From: Martyn White
Sent: 30 August 2019 10:25
To: Planning.Responses <Planning.Responses@arun.gov.uk>
Cc: Anita Gardner <Anita.Gardner@arun.gov.uk>
Subject: CM/38/19/PL & CM/39/19/L

CM/38/19/PL & CM/39/19/L

The Climping Mill site comprises a number of buildings which reflect its various past uses including residential, educational, and agricultural. Of note is the main listed Building (Climping Mill), Mil Thatch and Mill Cottage. The application relates to Mill Cottage which sits to the south west of the Mill and is a curtilage listed structure. It is a modest building with an 'angled L-shaped' plan form.

The Current Proposal

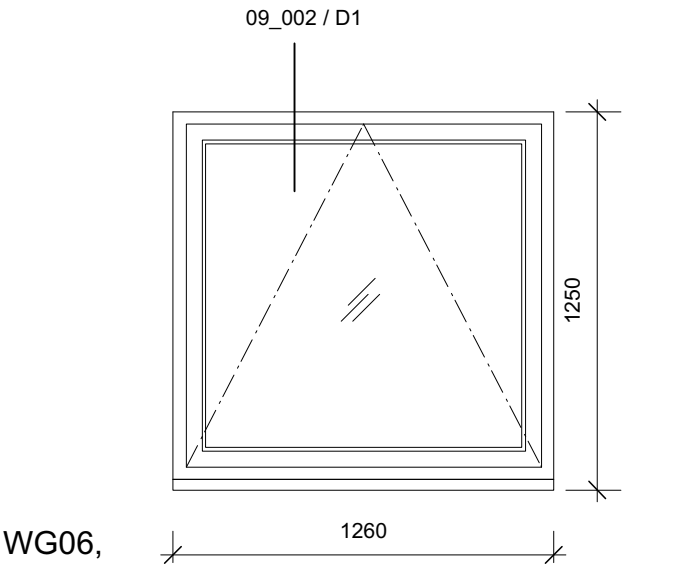
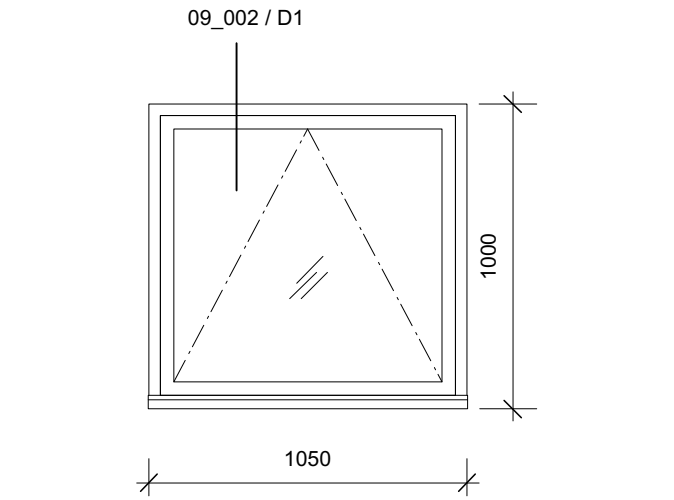
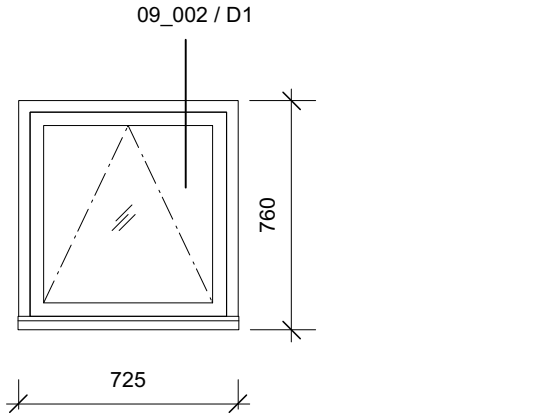
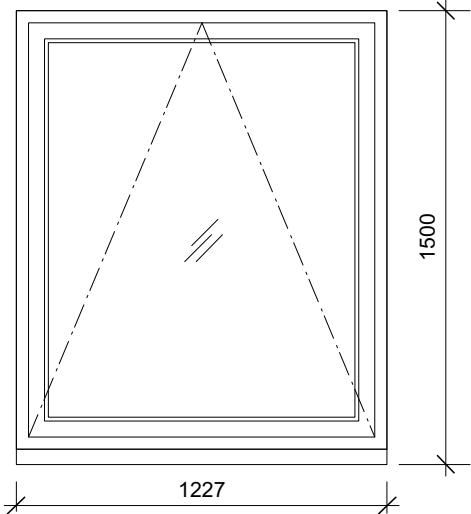
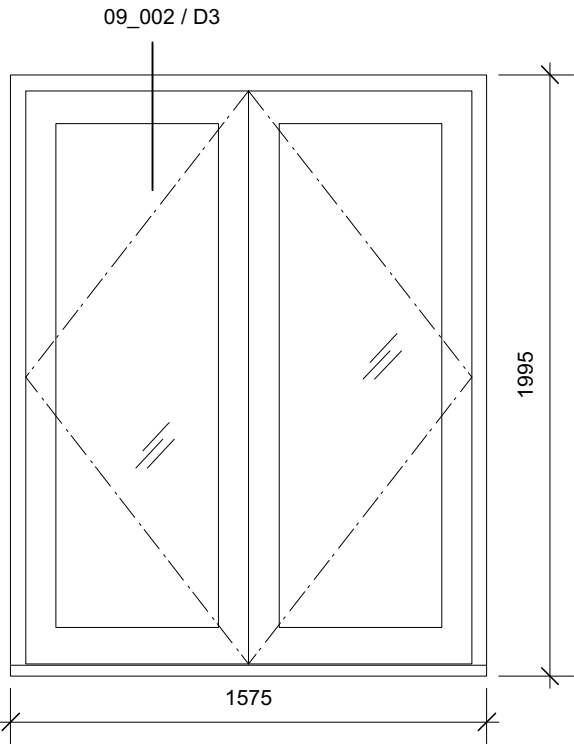
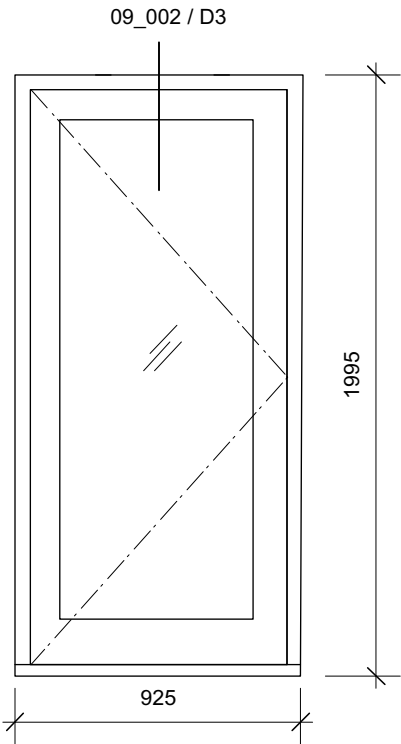
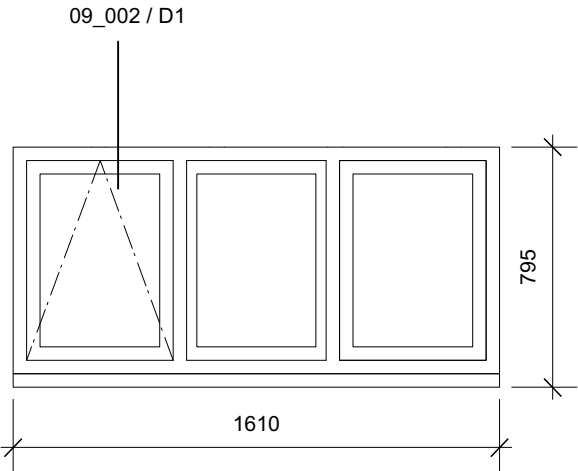
I note that an argument has been put forward for the simplification of the window and door joinery, and the introduction of shutters.

The simplification of the fenestration is a tricky issue to deal with. The removal of all of the glazing bars etc leaves what appears to be a series of large, blank openings. However, the use of the shutters will reduce the impact of the windows on the elevations. Therefore, on balance, the simplification of the window design is acceptable on this particular building.

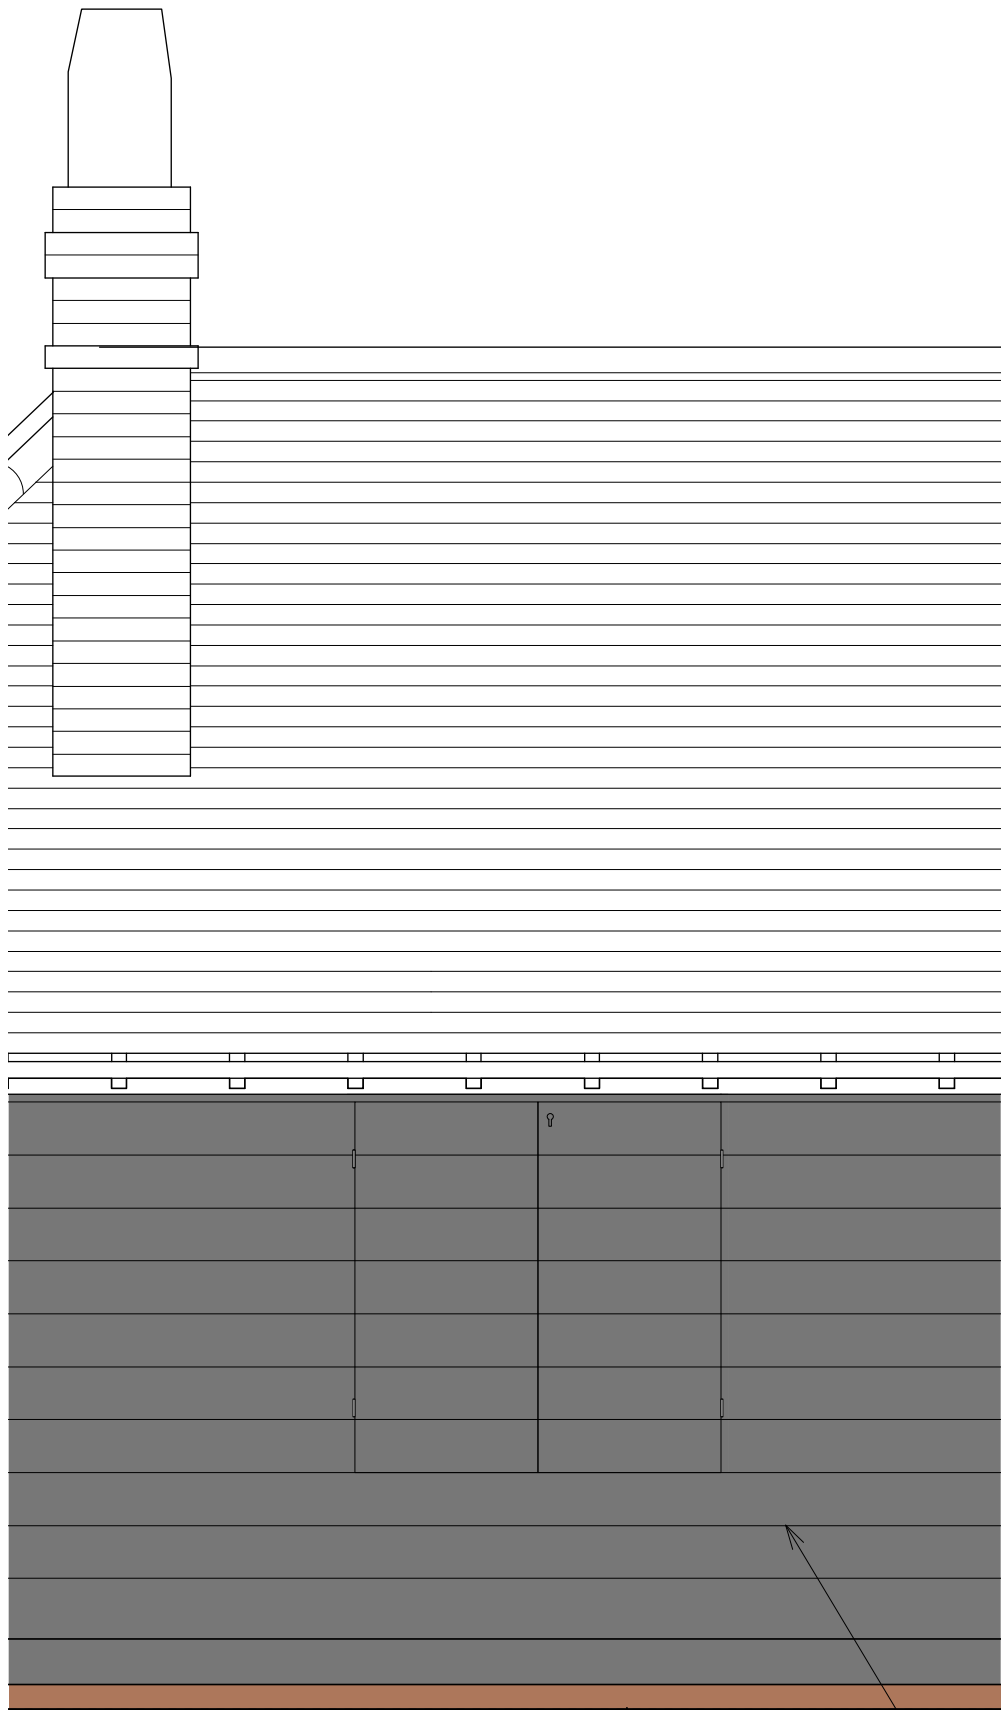
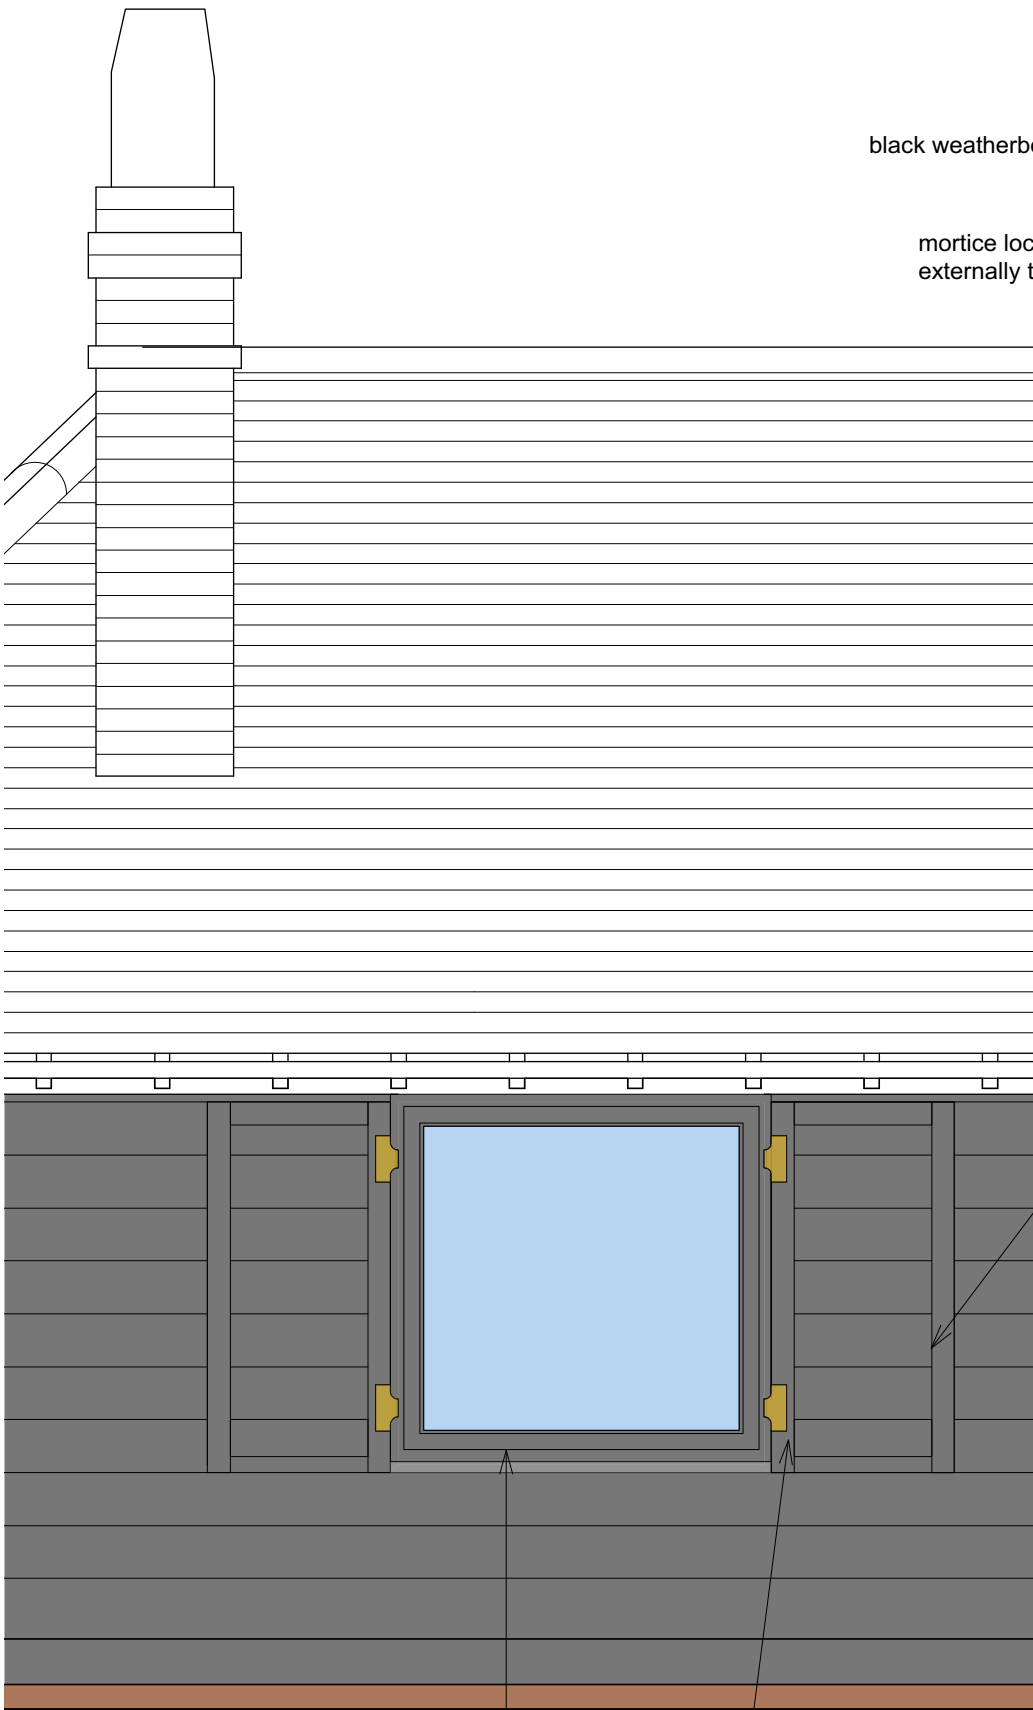
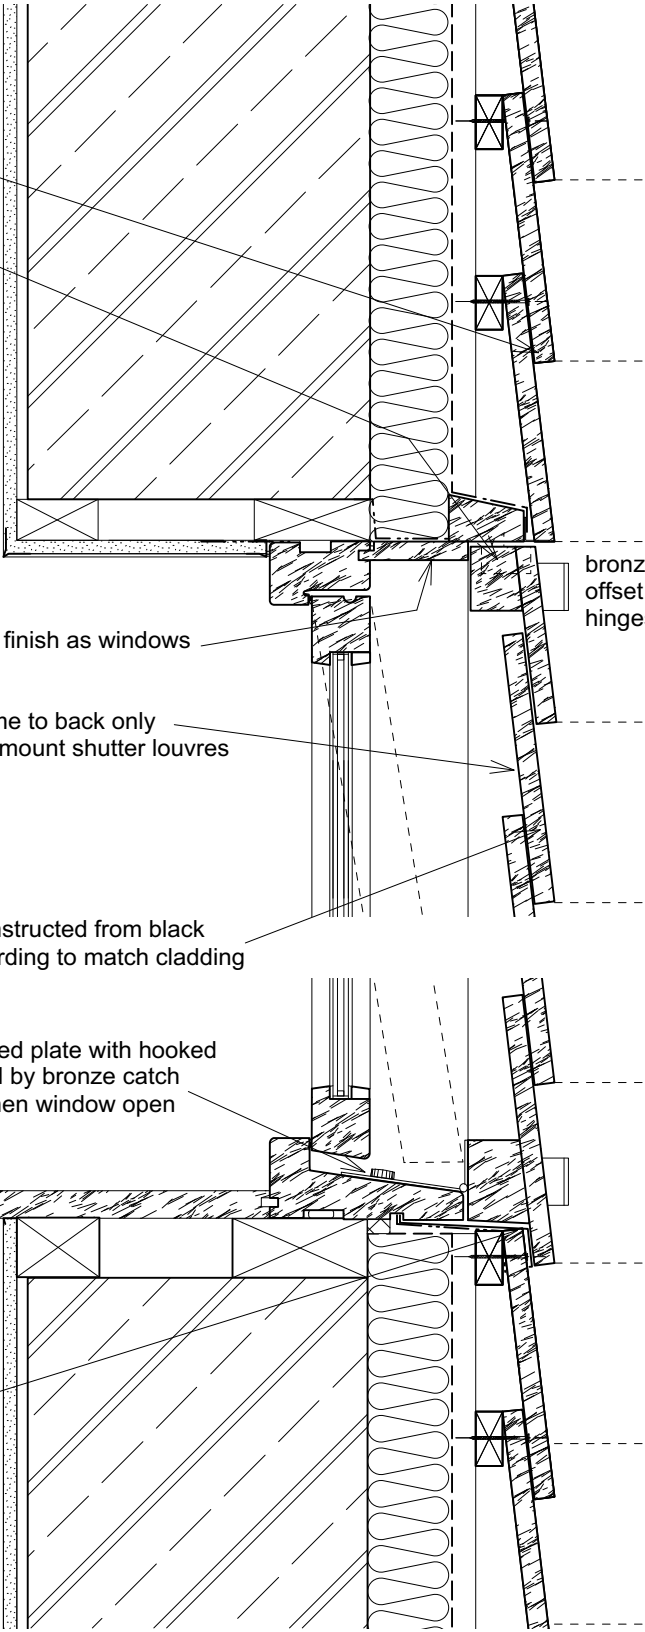
A historical photograph has been provided as evidence for their reintroduction on the building. This approach is considered to be most successful on the elevations where timber cladding has previously been approved. The introduction of the shutters on the other elevations will have to be carefully designed and considered so that they do not look like inappropriate introductions. Details have been provided for the sections of elevations covered with cladding, but not those elevations treated with flint. Such information should be supplied and discussed with the LPA.

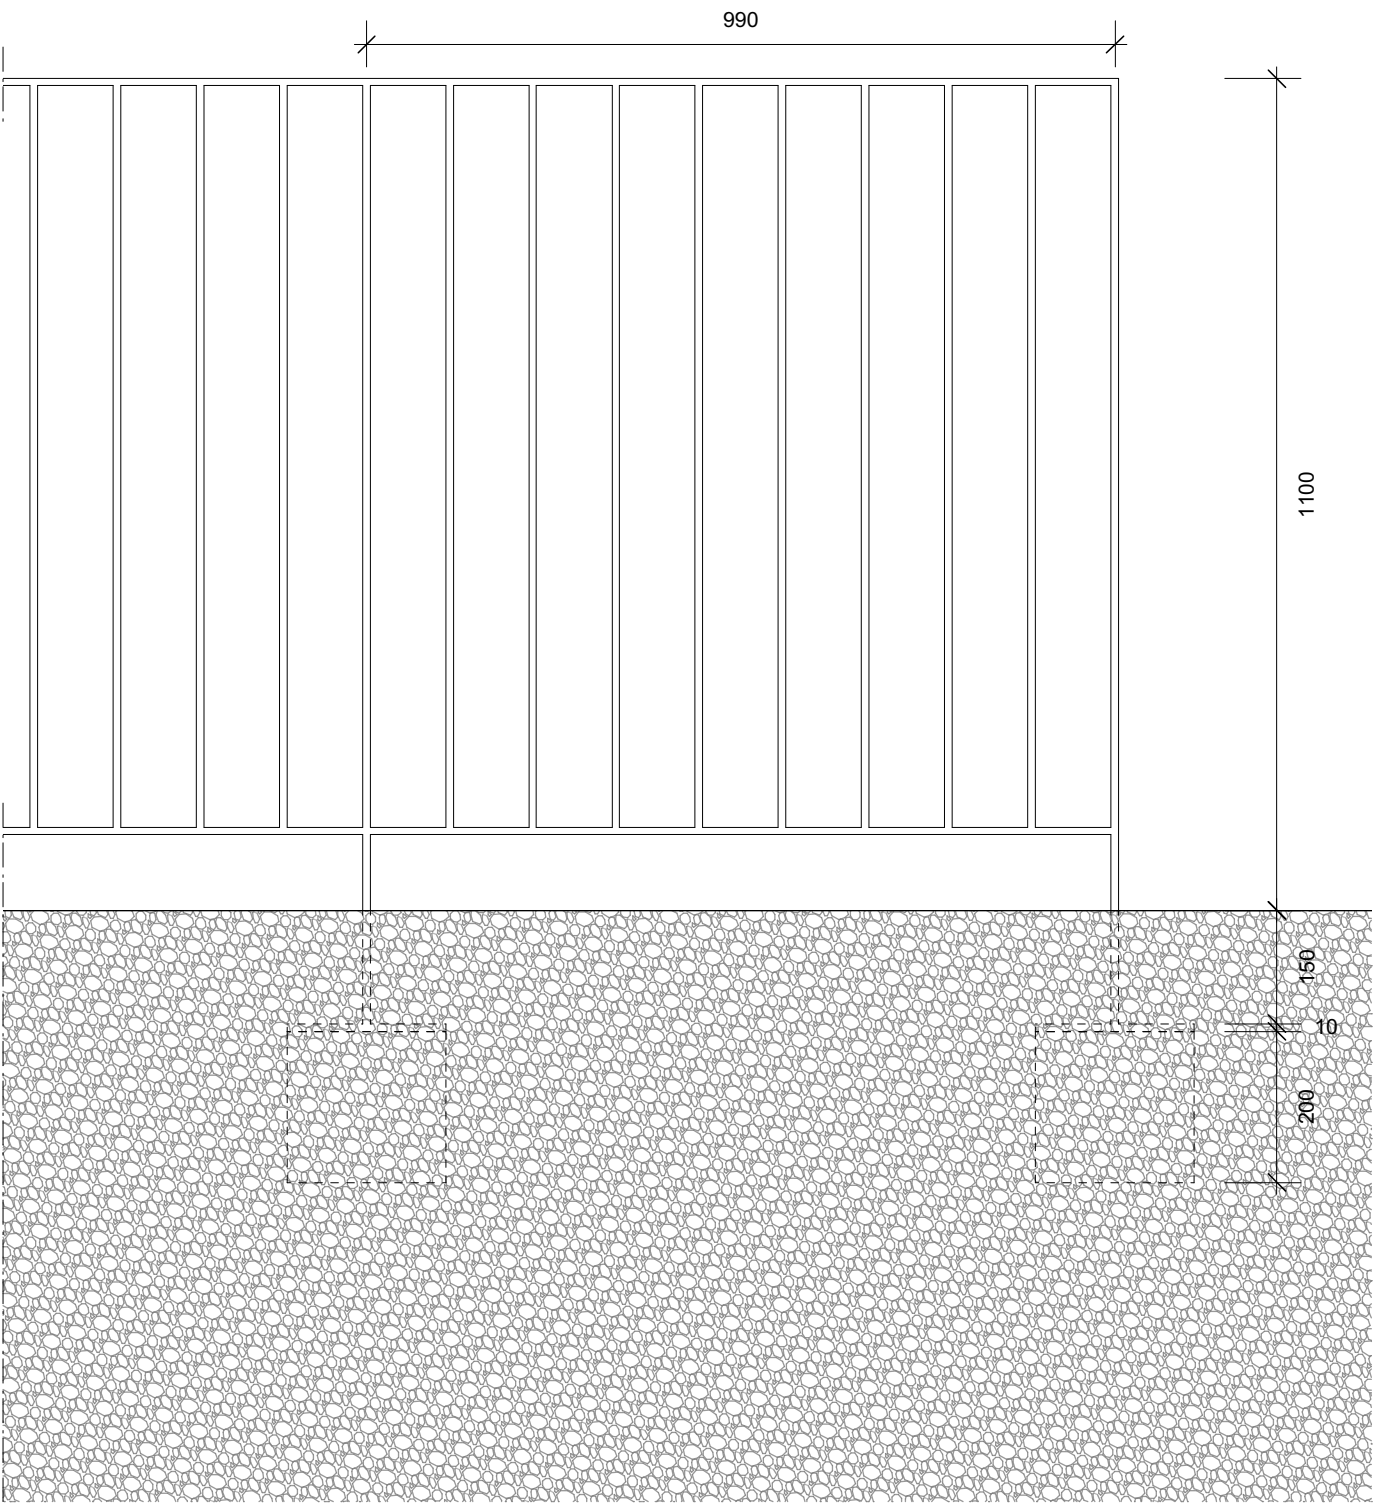
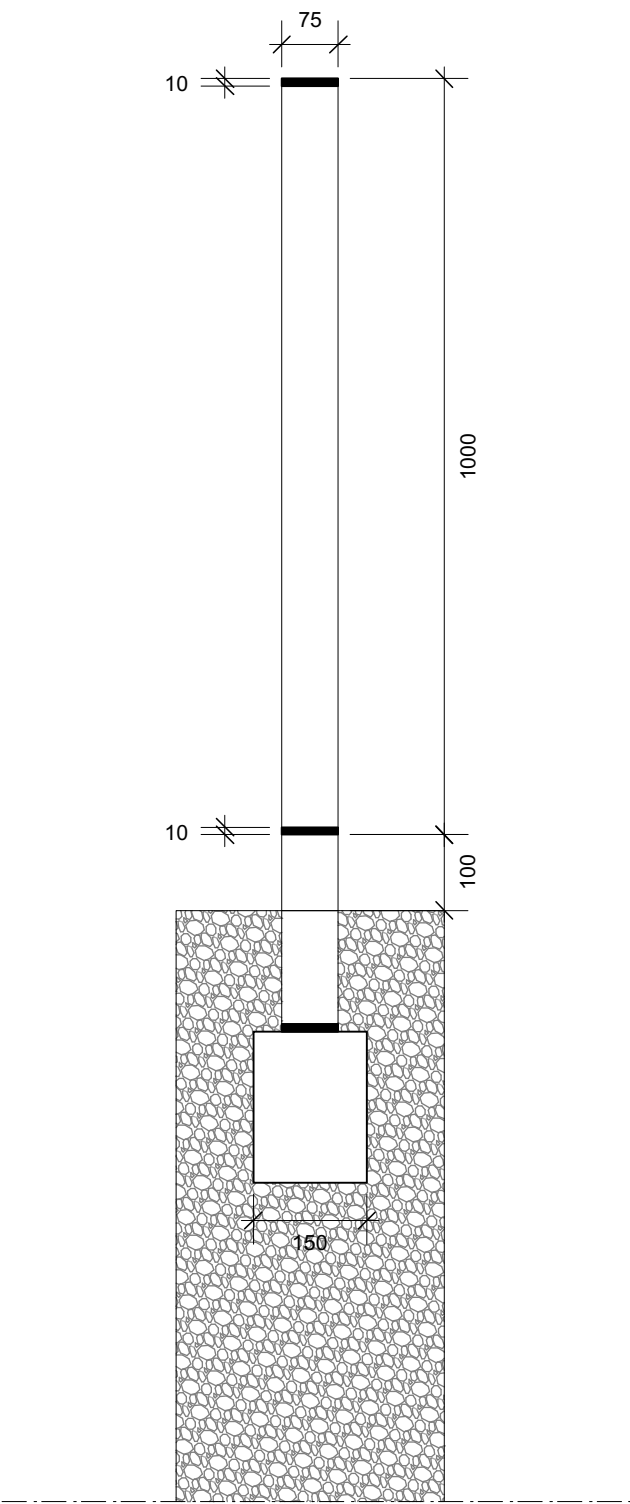
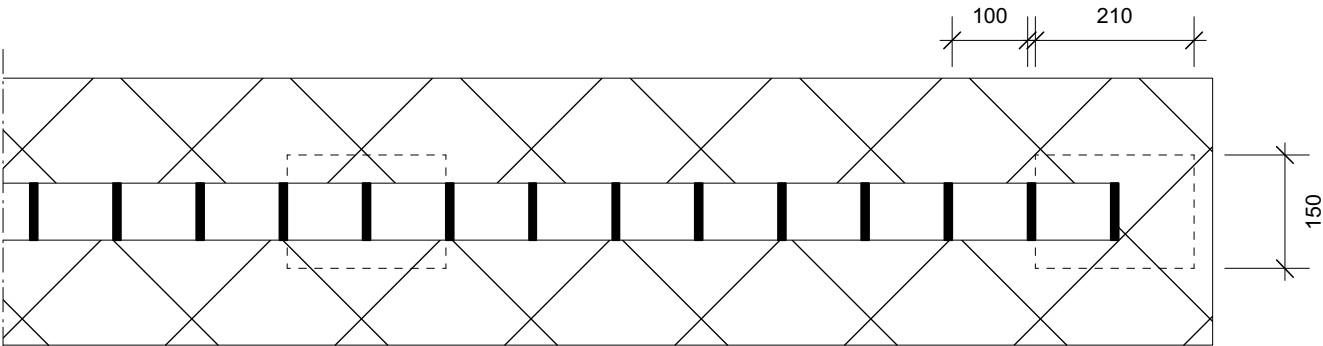
The railings are simple in character and appearance. This will not dominate the elevation and can be supported. However, they should have a painted finish and not powder coated one.
